CITY OF ALBUQUERQUE

**Re: Lowe's Market #99 – 4701 4th St NW
Erosion and Sediment Control Plan
Engineer's Stamp Date 3/9/2021 (F14D021)**

SHEET:
Erosion Control
Plan

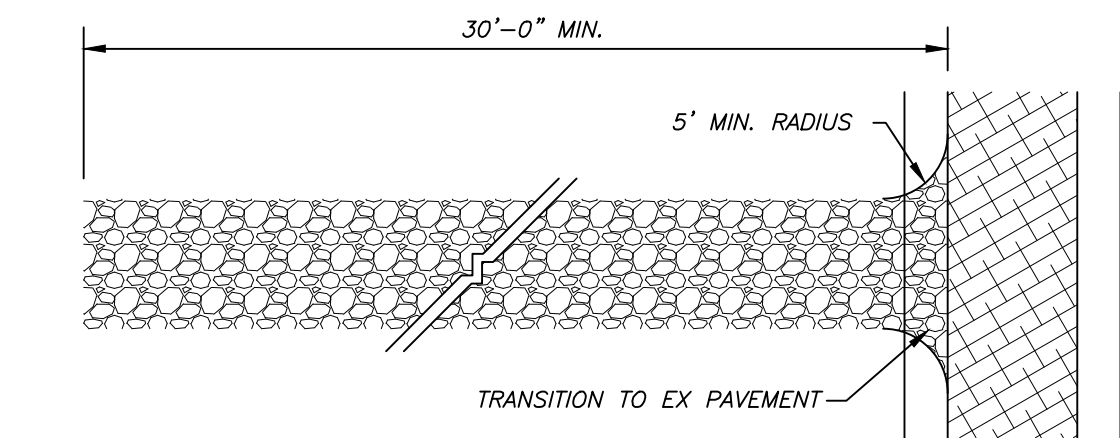
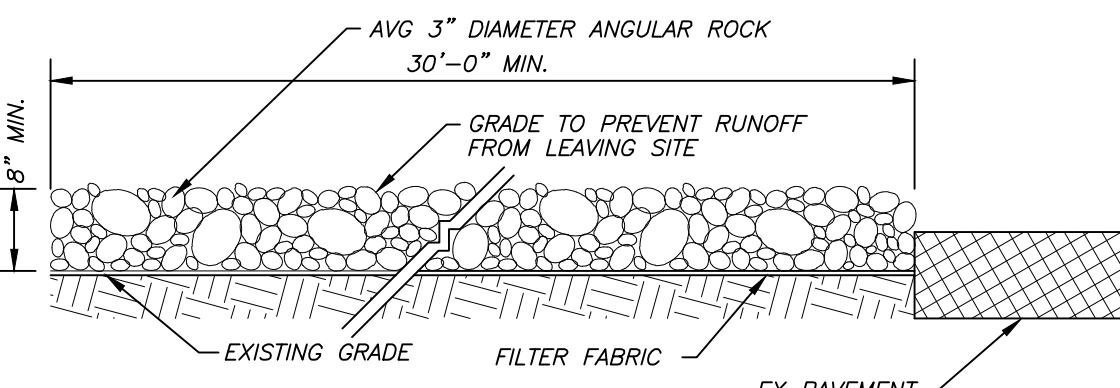
1. Show all lot lines on the plan. Provide plat showing vacation of lot line running thru building addition.
2. List operators on the plan, including name, phone #, and e-mail address. Include the developer/property owner's representative authorized to make changes to contract documents, plans, and specifications per CGP 7.2.1.

3. Identify stormwater team members responsible for sediment removal, BMP maintenance, and inspections on the plan, including name, phone #, and e-mail address. If unknown, leave blanks to be filled in later (CGP 7.2.2);

4. Describe the nature and extent of construction activities (CGP 7.2.2.), including a) nature of construction activities, b) size of the property, d) description of construction support activities.

5. Stabilization measures. Where you have a note on the ESC Plan that says see another sheet you must include that other sheet in the ESC Submittal and in the SWPPP, so the site plan and landscape plans are needed.

6. Soil information – add a table with name type, particle sizes, and Erodibility factor (CGP 2.1.1)
7. Update the engineer's stamp date each time the plan is changed.

8. Add the City Standard ESC Notes attached.
9. The ESC Plan can't be approved for Grading or Work Order until the property owner's NOI has been reviewed and approved by City Stormwater Quality.
